**Byers Gill Solar  
EN010139**

# 8.7 Comments on Local Impact Reports

Deadline 2 - August 2024

**Table 2-1 Applicant response to Darlington Borough Council’s LIR**

Figure 6 Ricknall Lane/Lodge Lane: road receptors 74 to 103 - aerial image

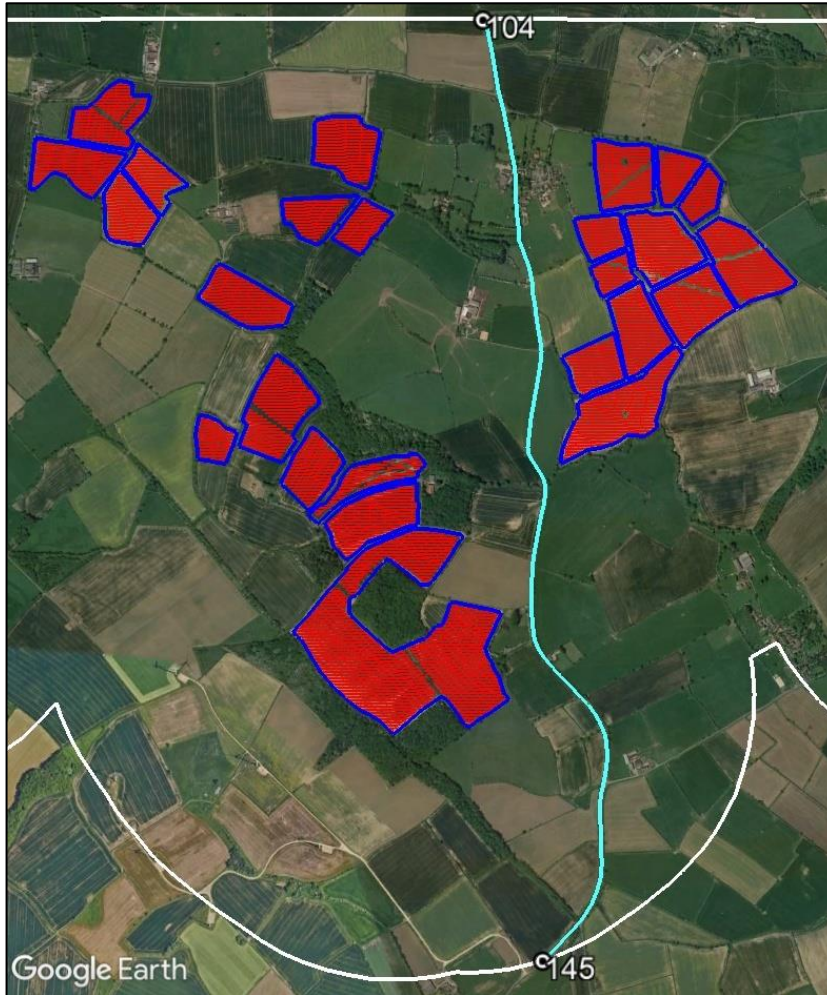
Reference	Topic summary	RWE response
	<p>(road receptors 90 – 91) of Ricknall Lane/Lodge Lane; together with a 1.5km section of Unnamed Road/The Green/High Street (road receptors 155 – 170). As is set out in more detail at Section 5.10 'Glint and Glare' of this LIR report, DBC would request that the ExA consider whether this assessment has been undertaken in accordance with best practice, and that consideration is also given to the timely delivery of any mitigation measures required for highway receptors and that they are maintained for the lifetime of the development by way of requirement. This matter is also set out in more detail in the main 'Glint and Glare' section of this report.</p>	<p>undertaking geometric calculations and intensity calculations where required. Glint and glare modelling has been undertaken at several points in the design process such that the findings of the assessment have informed the design of the Proposed Development, including measures such as screening as identified in the Outline Landscape and Ecology Management Plan [APP-118] and secured via Requirement 12.</p> <p>The study identifies that a moderate impact of glint and glare is predicted on three sections of road and ten dwellings, however with the planting and operational maintenance of that planting, as secured via the DCO, the impact would be reduced to low/none.</p>
